Our ref: DOC25/413031-12

**EPA Advice on Environmental Impact Statement
Hillview Hard Rock Quarry Project - SSD-70557215**

I am writing in response to your request for the NSW Environment Protection Authority (EPA) to review the Environmental Impact Statement (EIS) for the proposed Hillview Hard Rock Quarry Project (SSD-70557215) at 67 Maytoms Lane BOORAL.

Figure 6: 100th Percentile Annual Average PM₁₀ Concentration (Construction Scenario), Contour labels =5,10,25 µg/m³

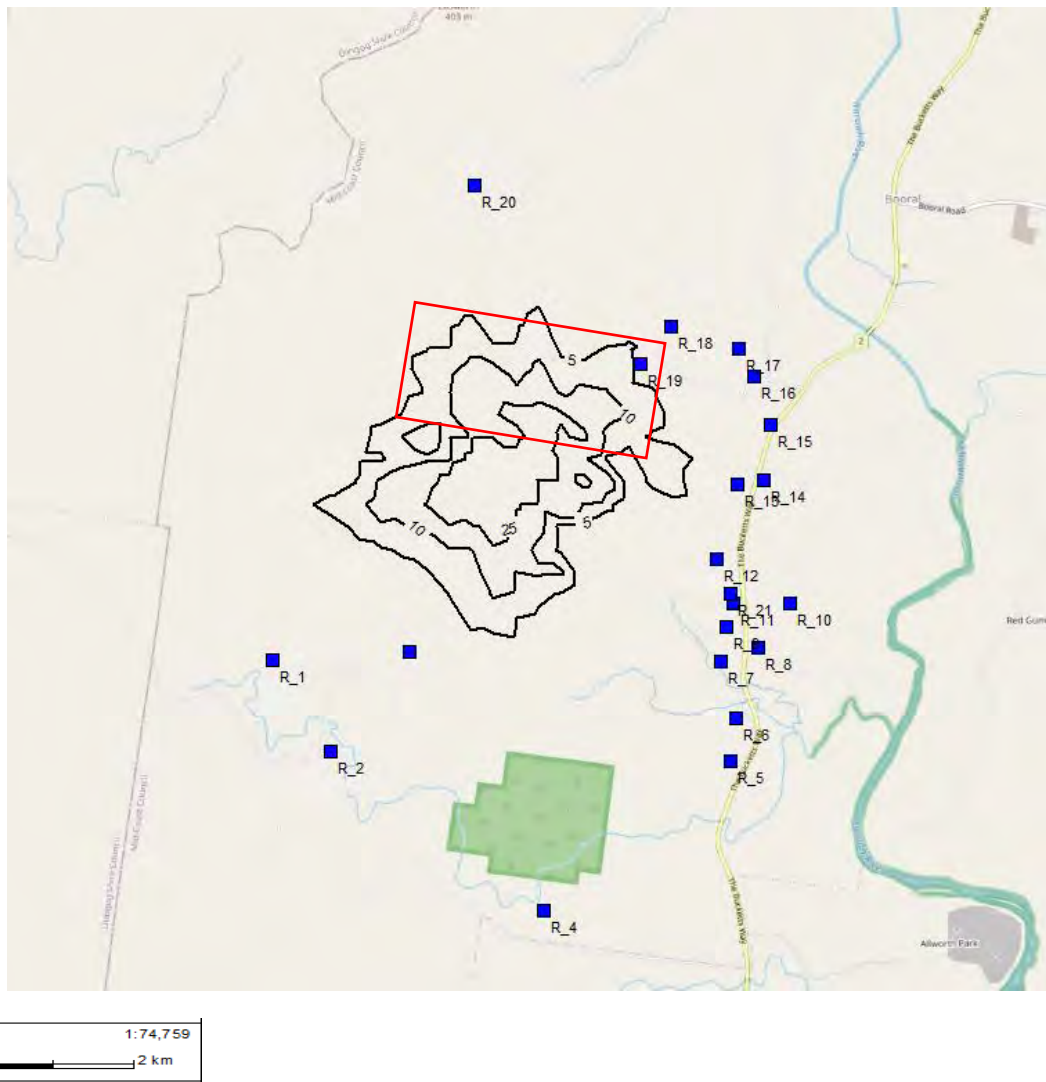
Both the construction and operational modelling scenarios predict additional exceedances of the 24-hour PM₁₀ criterion (50 µg/m³). For the construction scenario, the highest incremental impact (Table 9) is predicted to be 27.8 µg/m³ (55 % of the criteria) at R19 resulting in an additional exceedance of the 24-hour PM₁₀ criteria. For the operational scenario, while the highest incremental impact (Table 14) of 25.5 µg/m³ does not result in an additional exceedance, an additional exceedance is predicted at R12 with an increment impact of 8.4 µg/m³.

The AQIA states that these are “marginal” exceedances, are driven by high backgrounds rather than significant incremental contribution and are unlikely to occur on a regular basis. The AQIA also states that these exceedances are a result of many conservative assumptions included in the modelling. However, it is noted that wet deposition and default annual wind erosion emission factors were used and sand processing and conveyors were not included in modelling which make the modelling less conservative.

The EPA considers that the AQIA shows the project will result in significant incremental impacts and cause additional exceedances of the impact assessment criteria. The *Approved Methods for the Modelling and Assessment of Air Pollutants in NSW* (the Approved Methods) states that should additional exceedances occur following a contemporaneous assessment, more effective mitigation measures or emission controls should be applied and the impact assessment revised.

- a) reviews the AQIA to ensure assessments and references to extraction and processing of sand and sandstone aligns with the lodged description of hard rock quarrying of rhyolite.
- b) revises the AQIA to include additional mitigation measures to achieve compliance with the assessment criteria. This is to include any reactive measures required to achieve compliance.
- c) commits to and confirms the implementation of all the mitigation measures recommended in the AQIA and included in the revised modelling. If reactive measures are required, details of which activities are stopped at which meteorological conditions and/or particulate concentrations must be clearly identified.
- d) details how the compliance will be achieved through mitigation measures. This is to include but not be limited to, the details of monitoring (type and locations) and the triggers and actions to manage impacts.
